Harnett County Government Complex
307 Cornelius Harnett Boulevard
Lillington, NC 27546

October 11, 2005

RE: Harnett County Land Use Application 05-5-13134R

Option #1

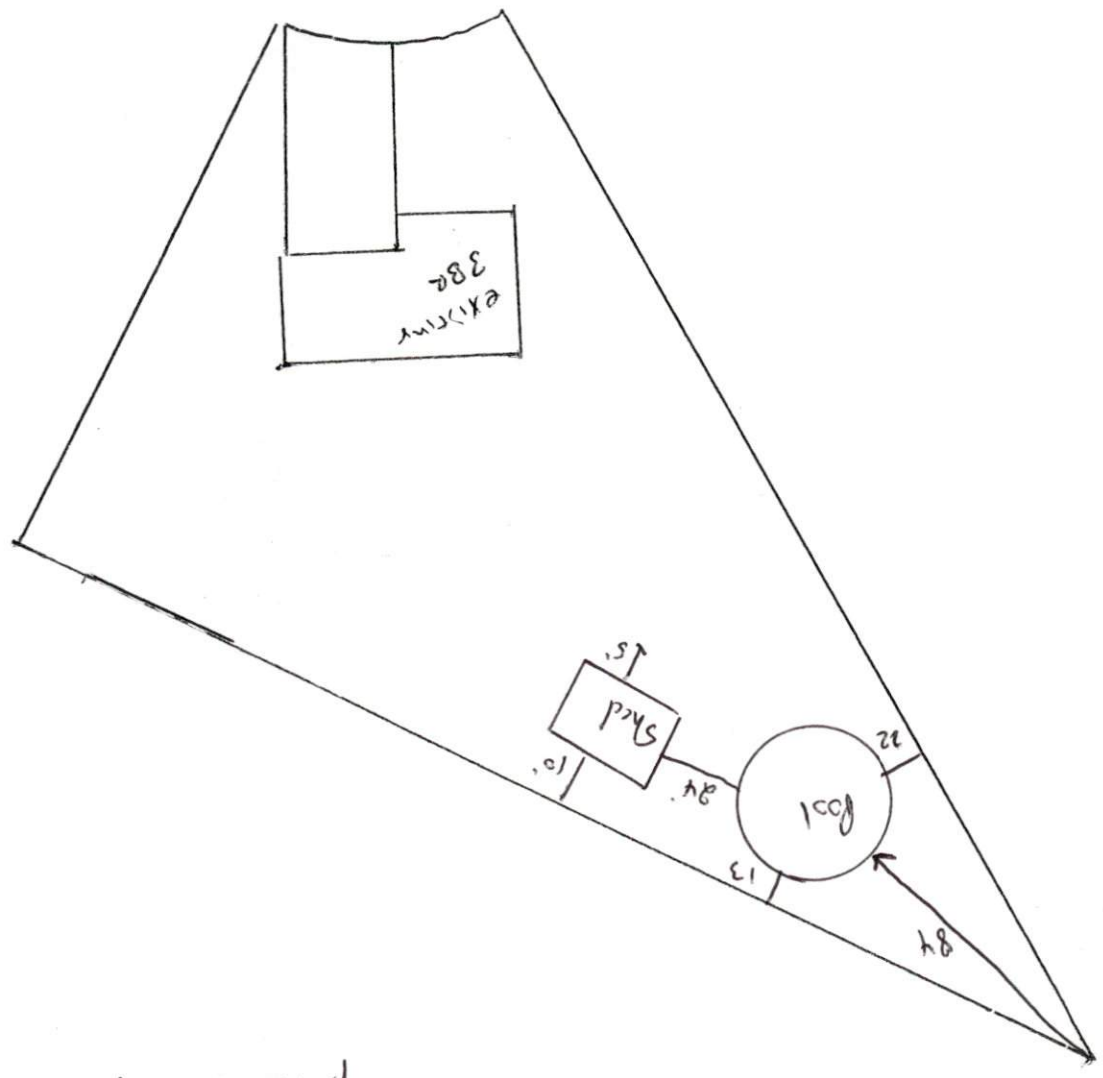
Option #1 is to move the
Pool as shown. No work
on the septic system would be
required - other than fixing any
chambers damaged.

Option # 2

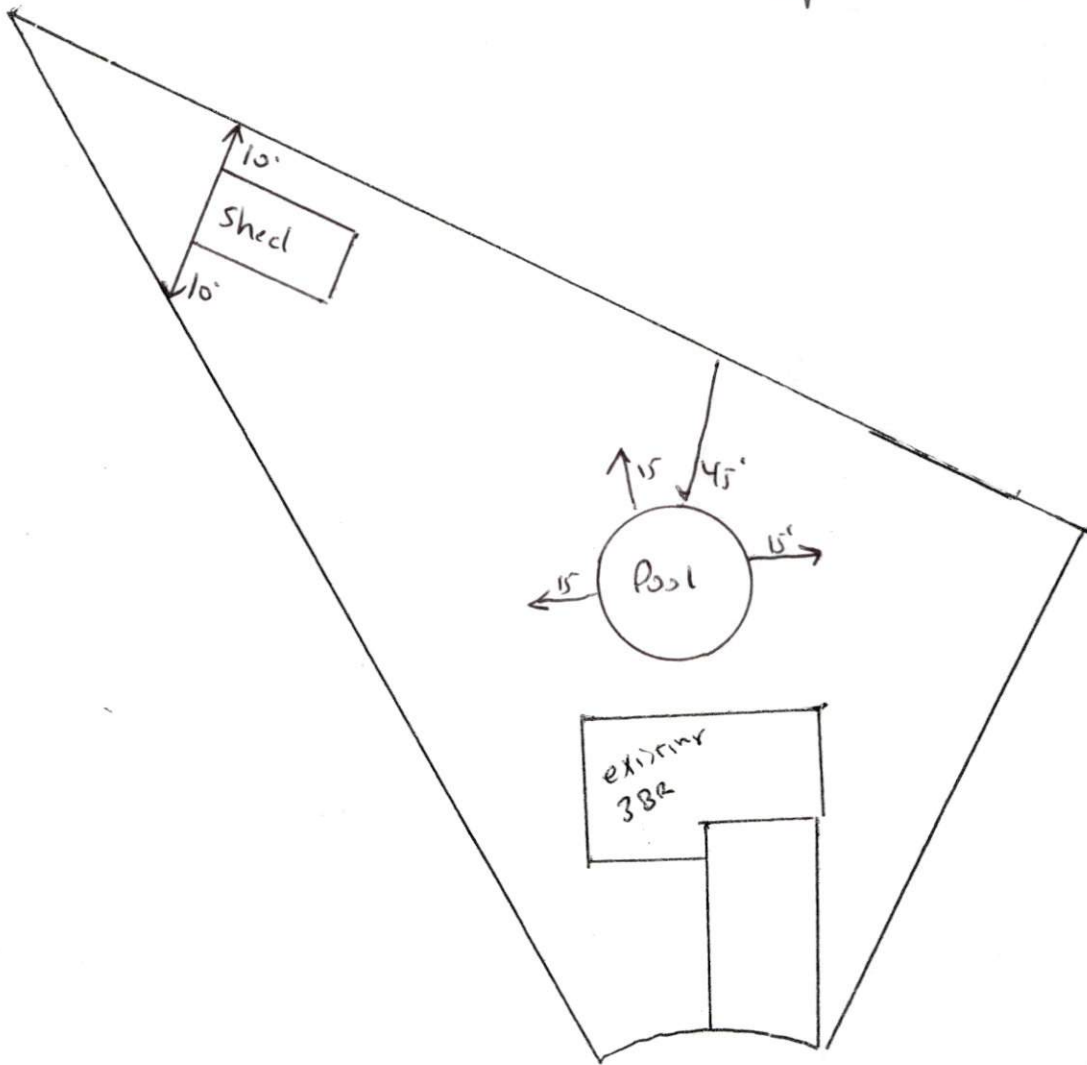
Option # 2
Is to move the Building,
Leave the pool as is and install
a new septic system. This new
septic system would require a
new tank, a pump tank and
new line

Option 3

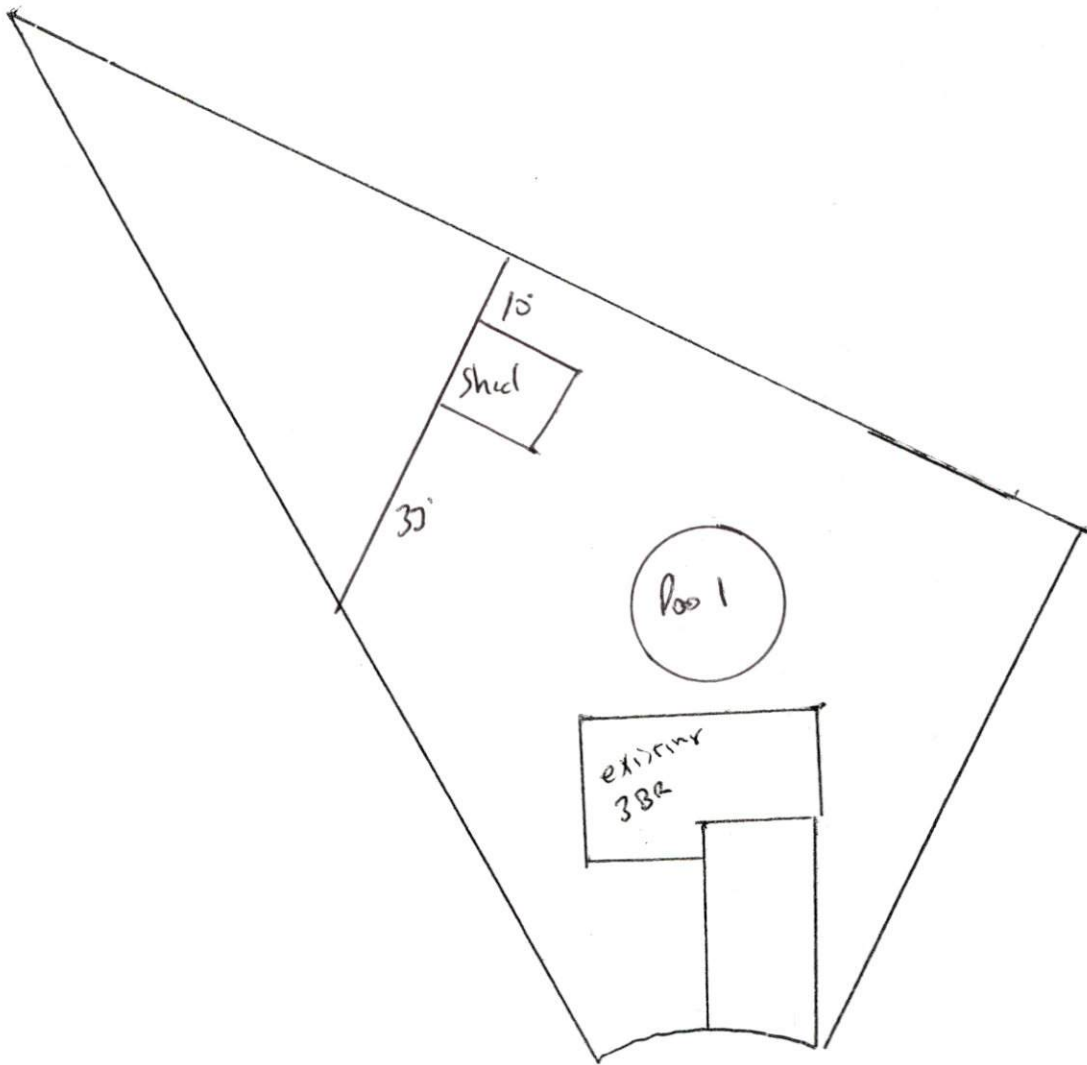
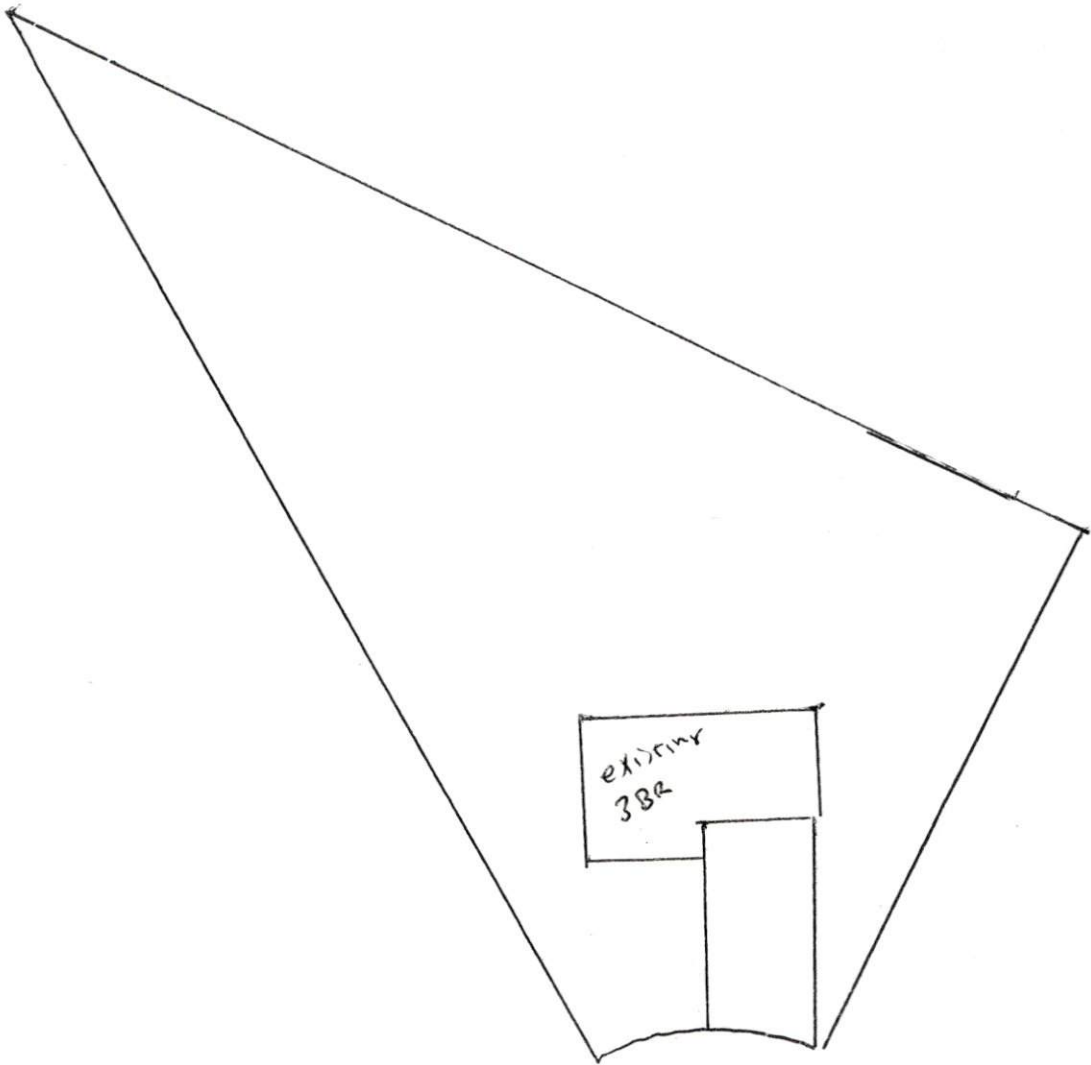
Option 3 is to leave pool &
Building as is and have a
private consultant design you
Any alternative septic system
And Repair Area.
